Preliminary Acceptance Punchlist
El Paso County – Department of Public Works - Stormwater Section

Project Name:	Paint Brush Hills F14
EDARP Filing Number(s):	SF2024, CON2158
ESQCP Number:	ESQ2110
Attendees:	DPW SW: Dylan Finley DPW Development Services: Brad Walters Developer: Chris Ewen
Date of Walk-through:	08-06-2024
Walk-through Number:	2 nd

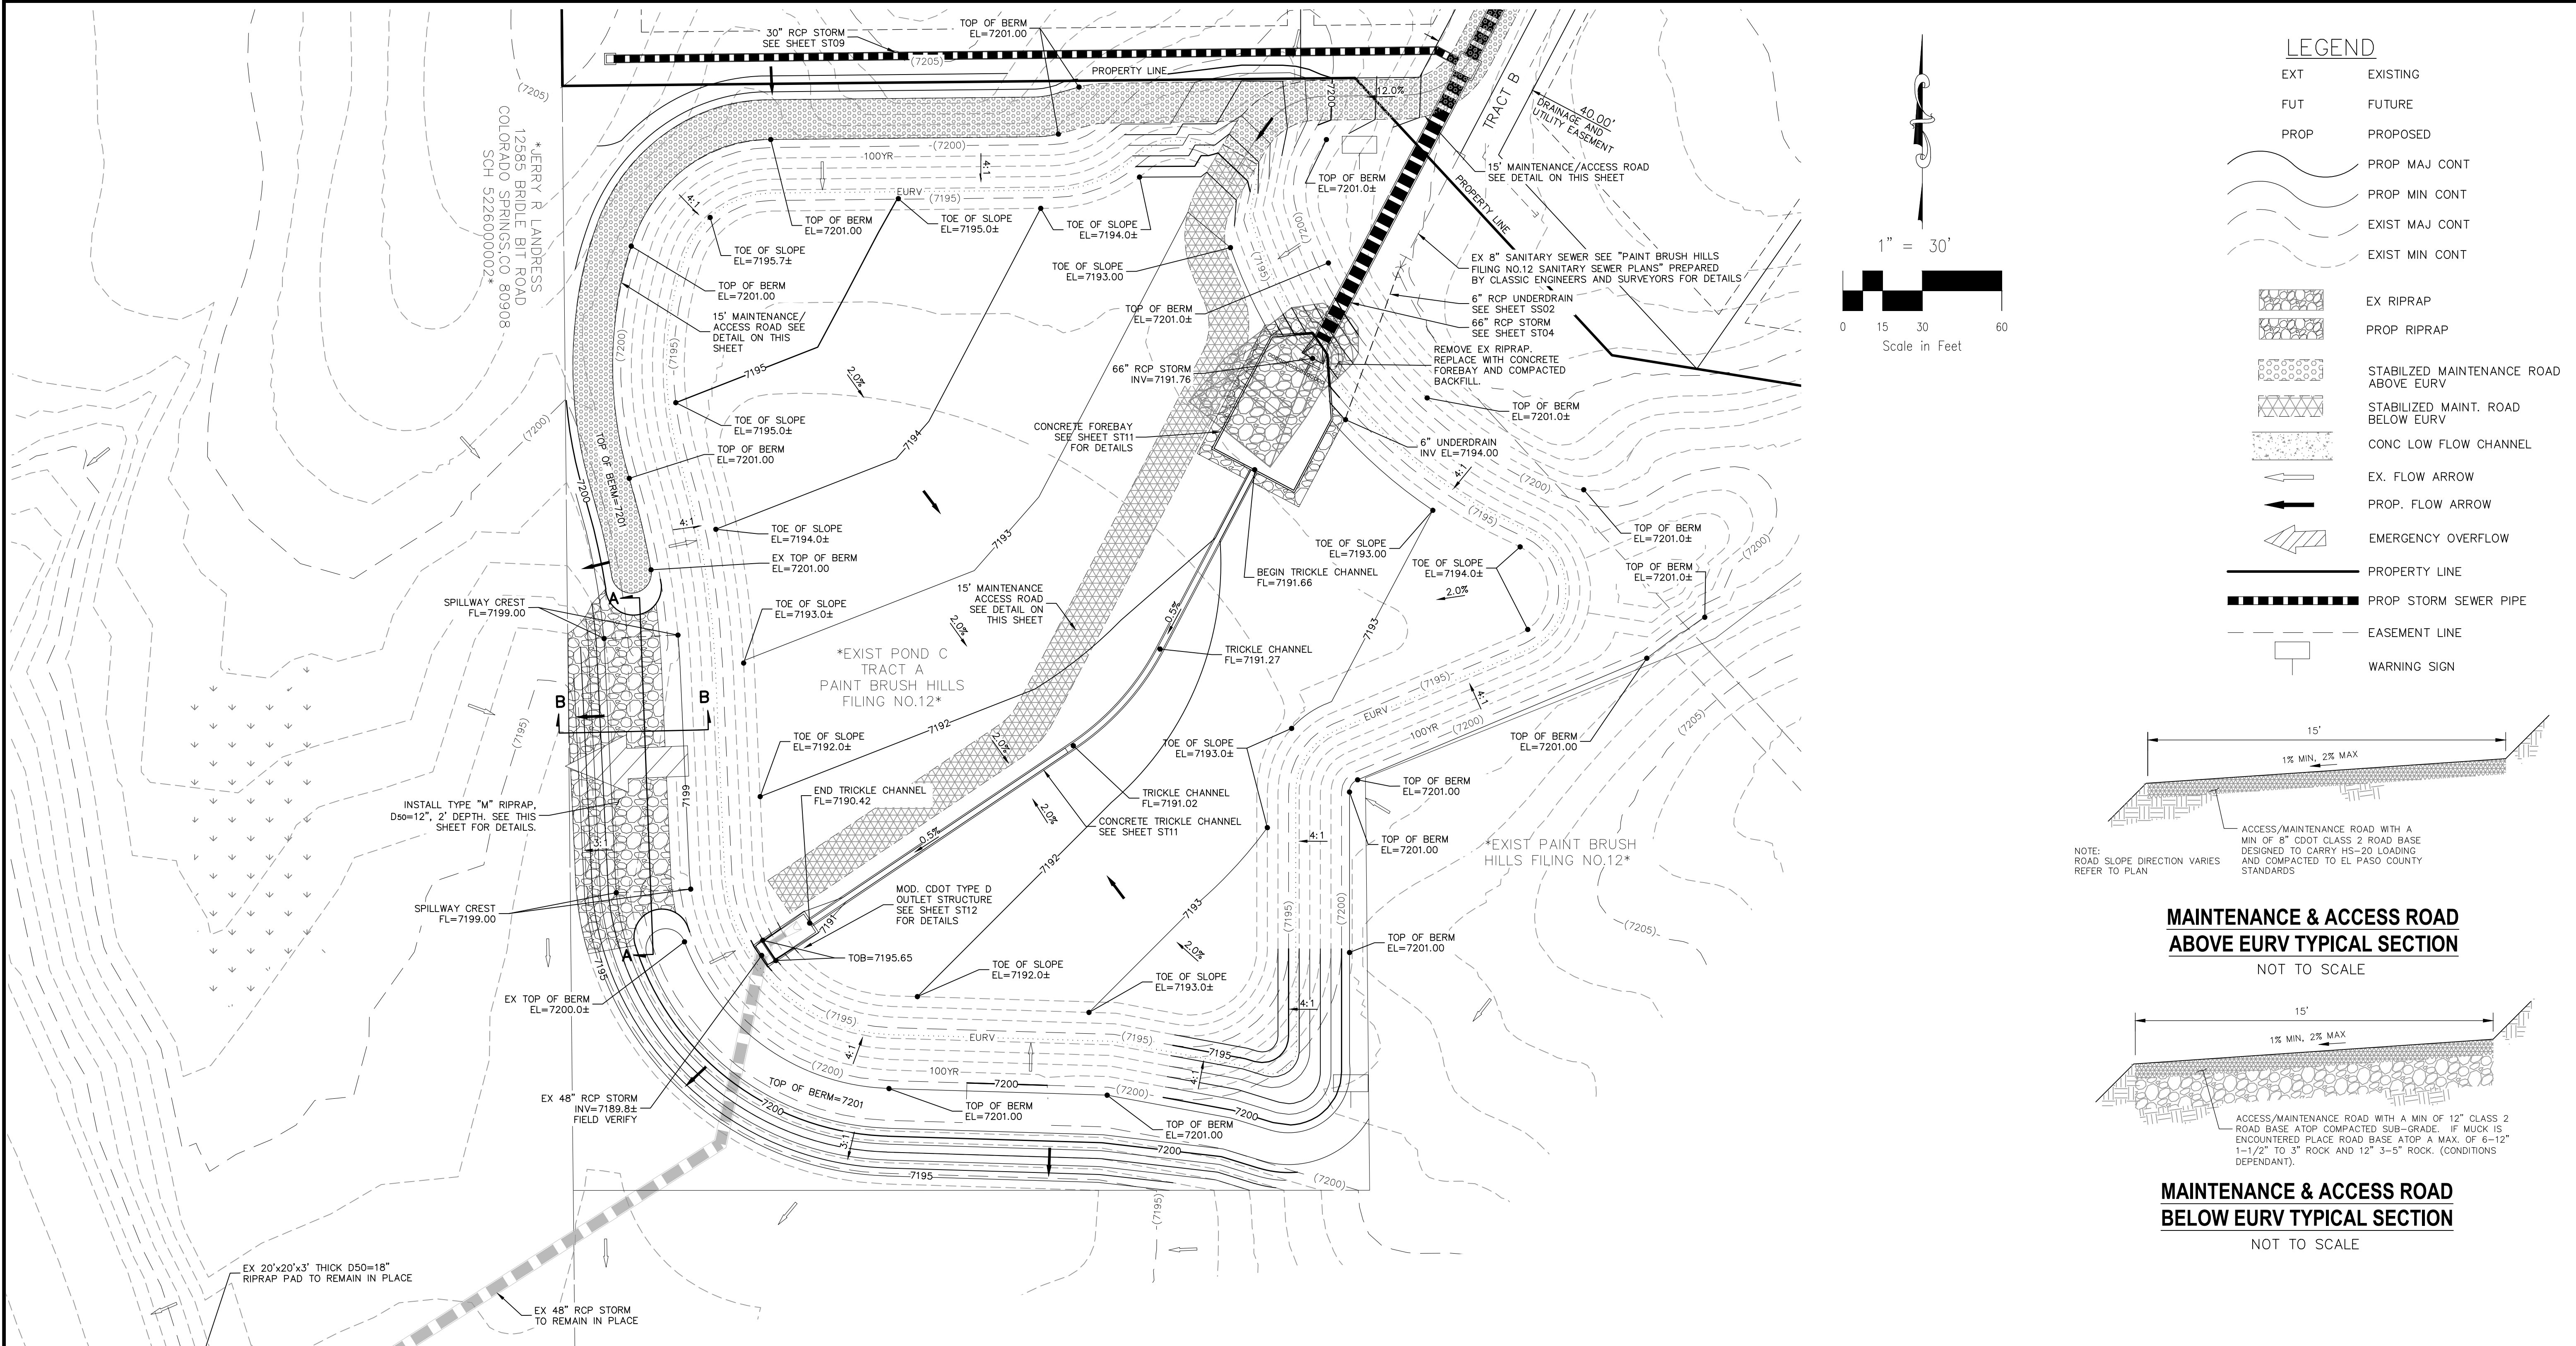
- Regrade pond bottom to top of trickle channel curb with a 3% slope towards trickle channel for positive drainage. Stabilize pond bottom where disturbance occurred.
- Maintenance road not installed per plan. Install per approved plans. Reference Construction Drawings Sheet 28 of 30.
- Remove sediment, vegetation, and debris from pond components. (Forebay, Trickle Channel, and Mircopool)

Photo 1: Maintenance Road not installed per plan. Install per approved plans. Reference Sheet 28 of 30 of CDs.
